Date: 09 January 2026
Our ref: 534905
Your ref: 2382/APP/2023/2906

Planning consultation: Amendment: Redevelopment of Site to create the Hillingdon Water sports Facility & Activity Centre and other associated works.

Location: Broadwater Lake, Moorhall Road, Harefield

SUMMARY OF NATURAL ENGLAND'S ADVICE

0 50 100 150 200 300 400 500m

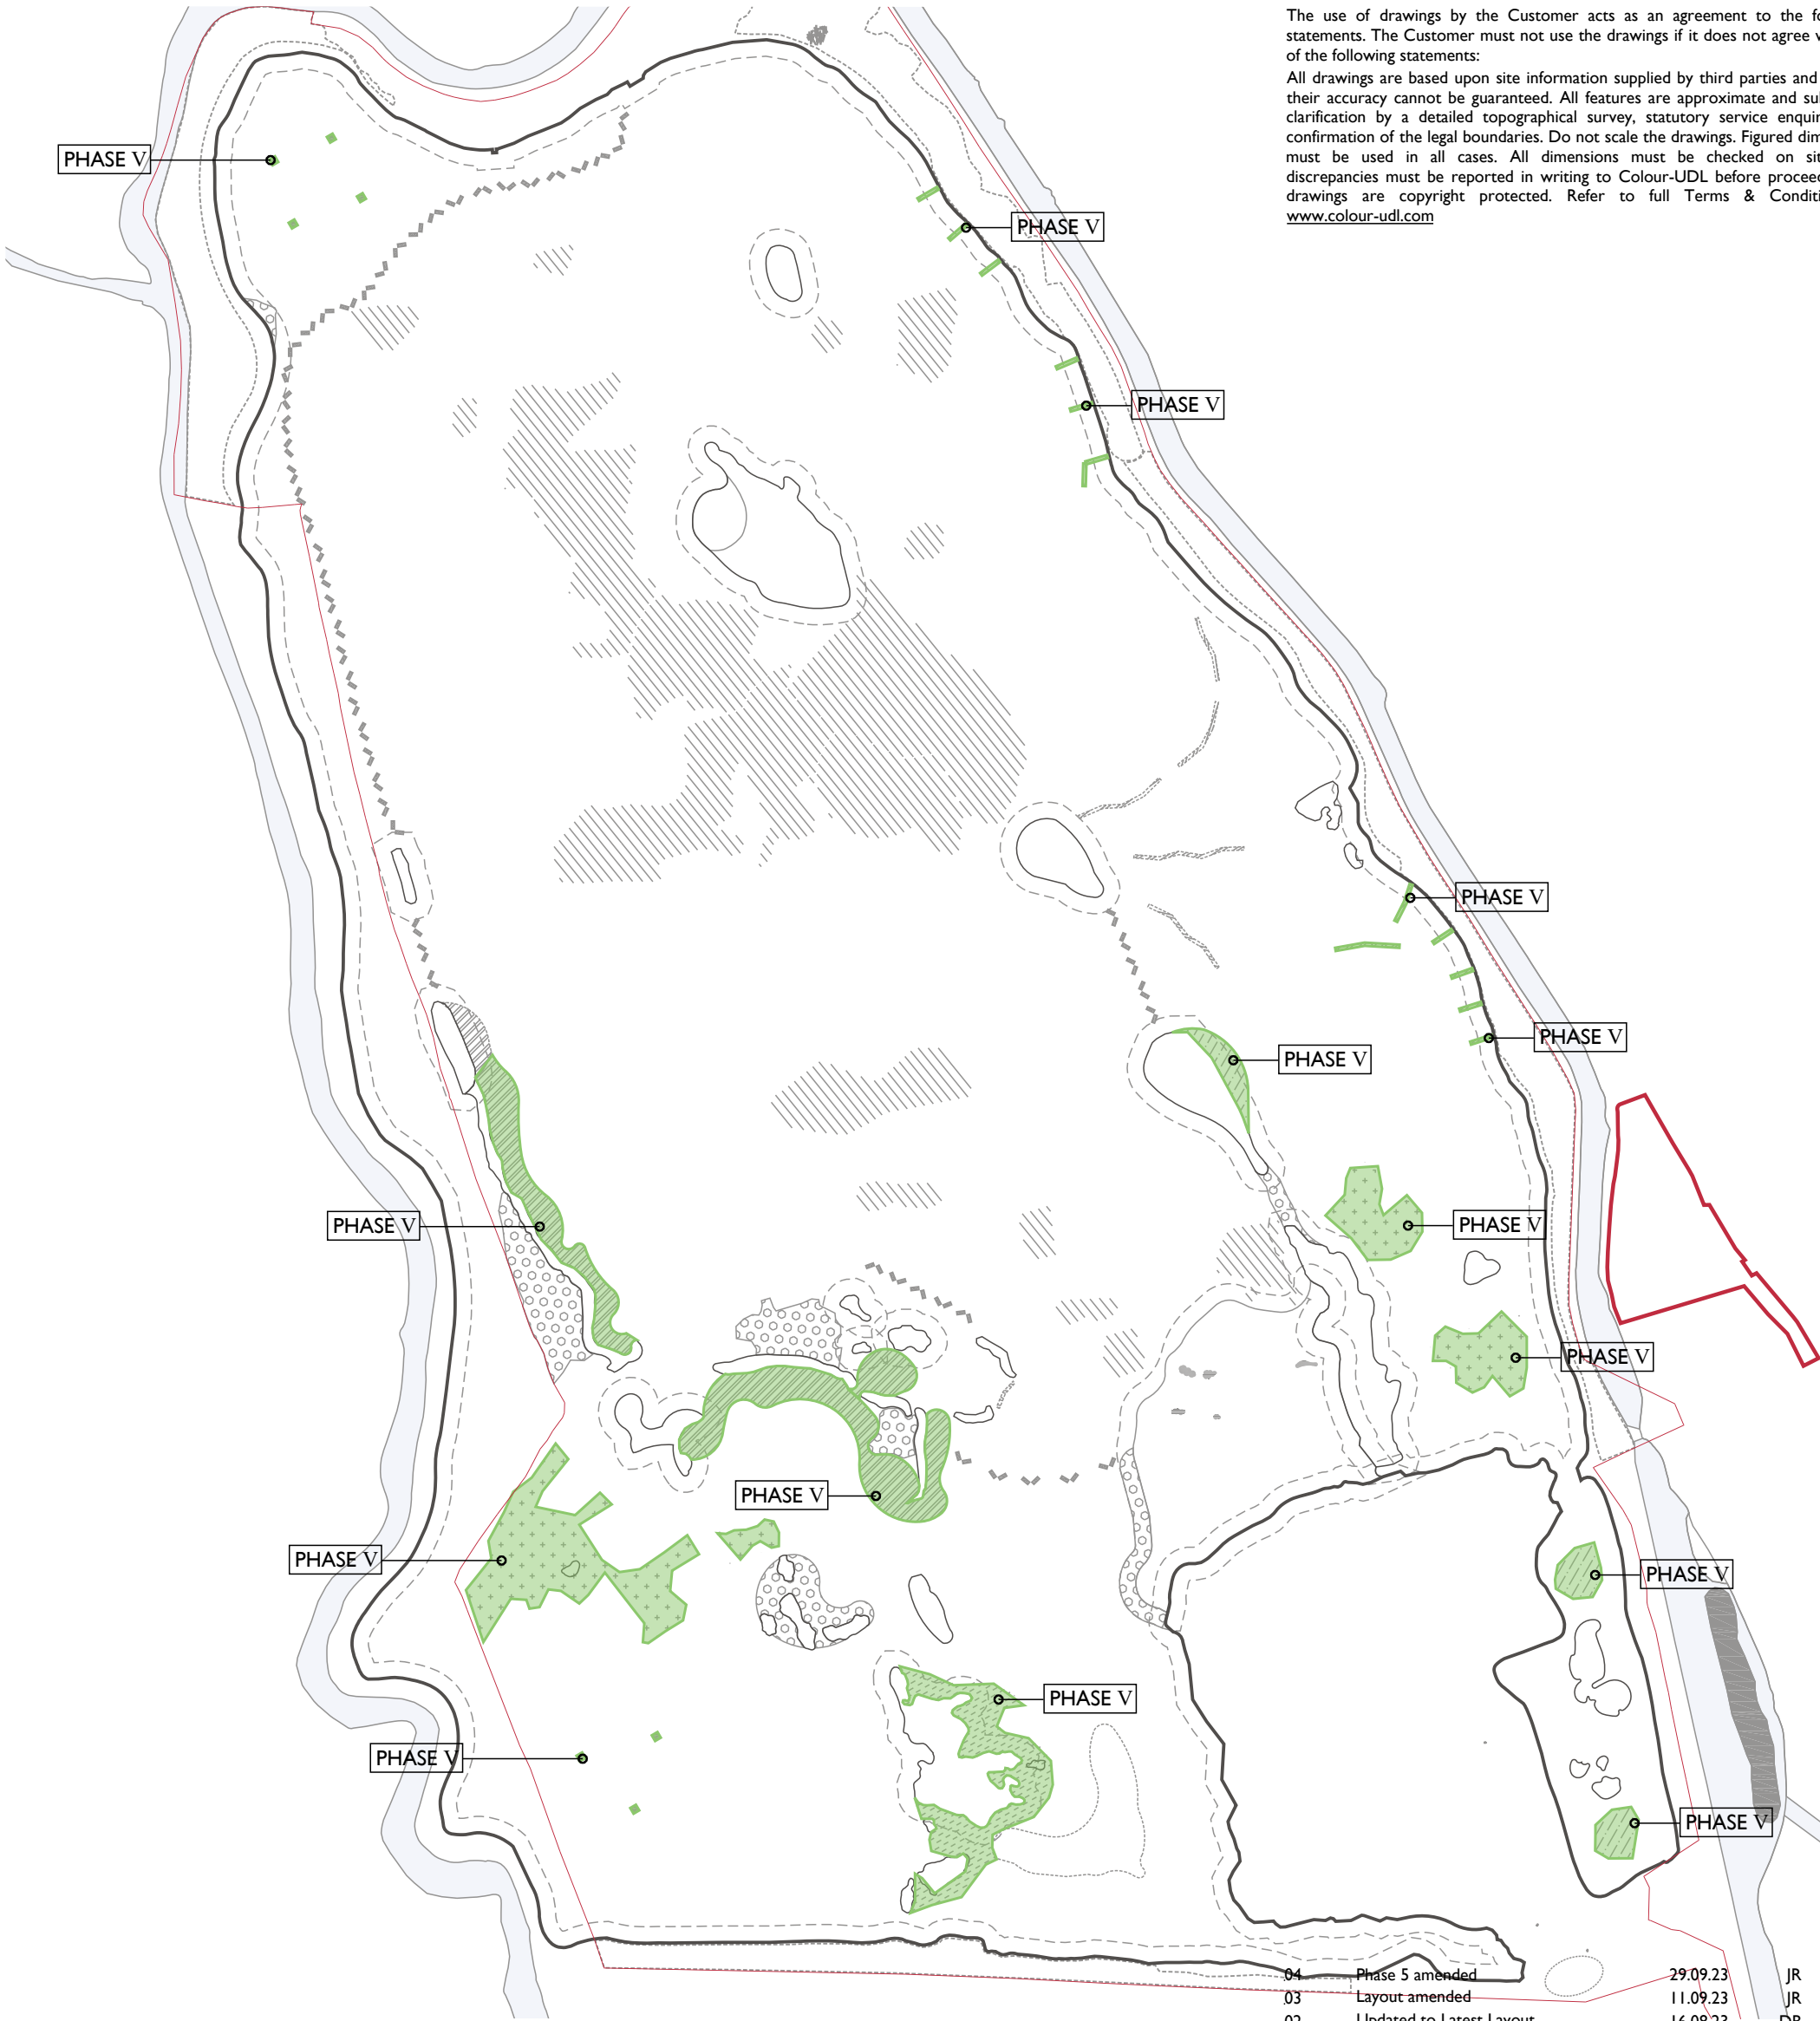
We apologise that we hadn't previously noted the importance of the site during the late summer months for the over wintering birds. We have reviewed the WeBS data for the site for the last three years and noted that in some years August and September have peak numbers of tufted ducks (*Aythya fuligula*). This information re-enforces the importance of the year-round refuge area on the lake, and the need to ensure that there is a refuge area during both construction and operation.

While Natural England view the refuge area as suitable mitigation to minimise impacts to moulting tufted duck numbers during operation, we would advise that construction schedules should be adjusted to take account of this. While we have previously advised that September is the best month for noisier construction activities, we now advise that these activities (such as demolition and piling) should take place during October – December. While these are still sensitive months and mitigation will be needed, this avoids the breeding and moulting season, and later winter months where it is likely to be colder with less food available for the wintering birds.

Figure 1: Location of permitted land-based activities

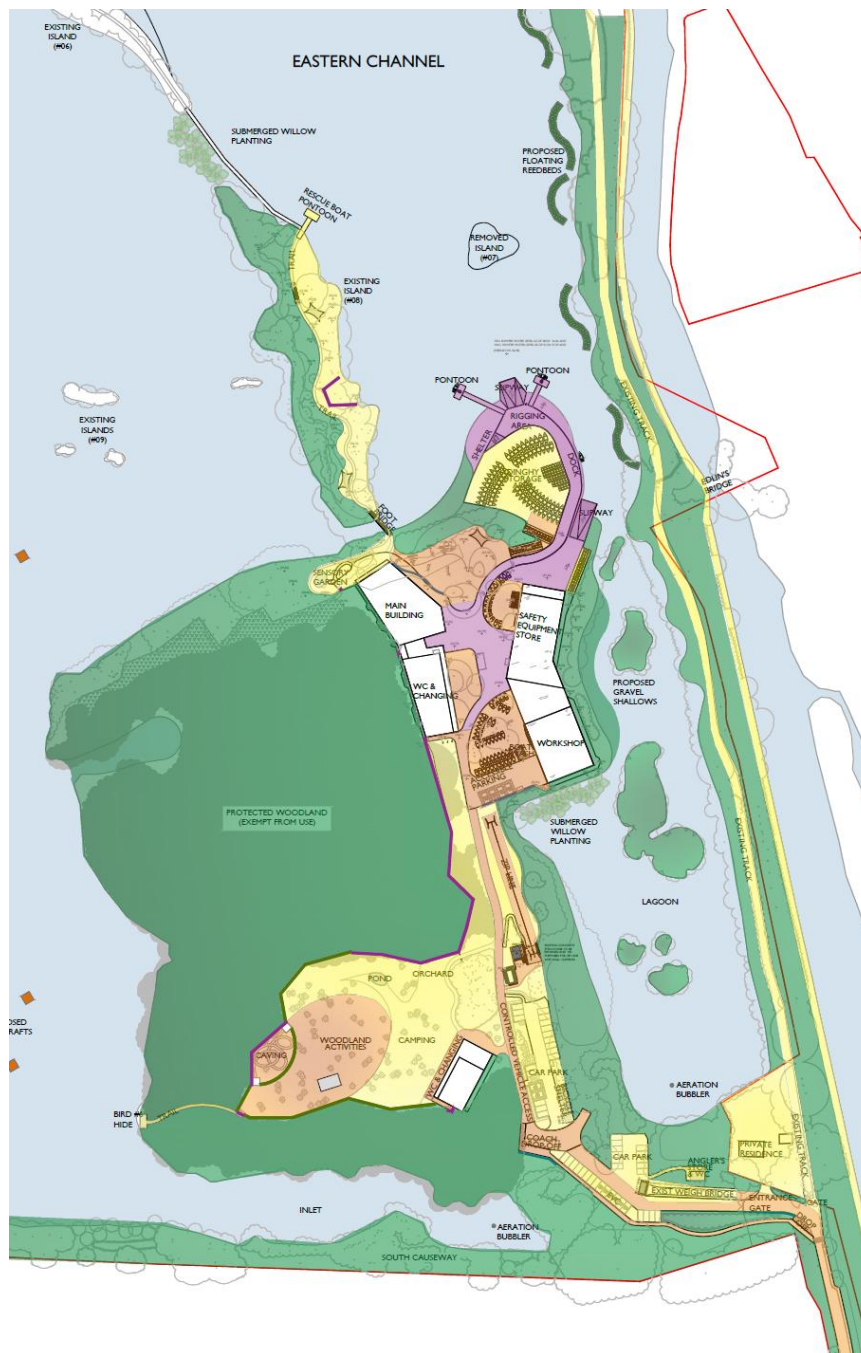
There are some discrepancies in the documents around the provision of land-based activities. Pages 15 and 17 of the Non-Technical Summary of the Environmental Statement provide conflicting lists. It was Natural England's understanding that activities such as the zip line and big swing had been removed from the proposals due to their potential impacts on wildlife on the site and we are supportive of their removal.
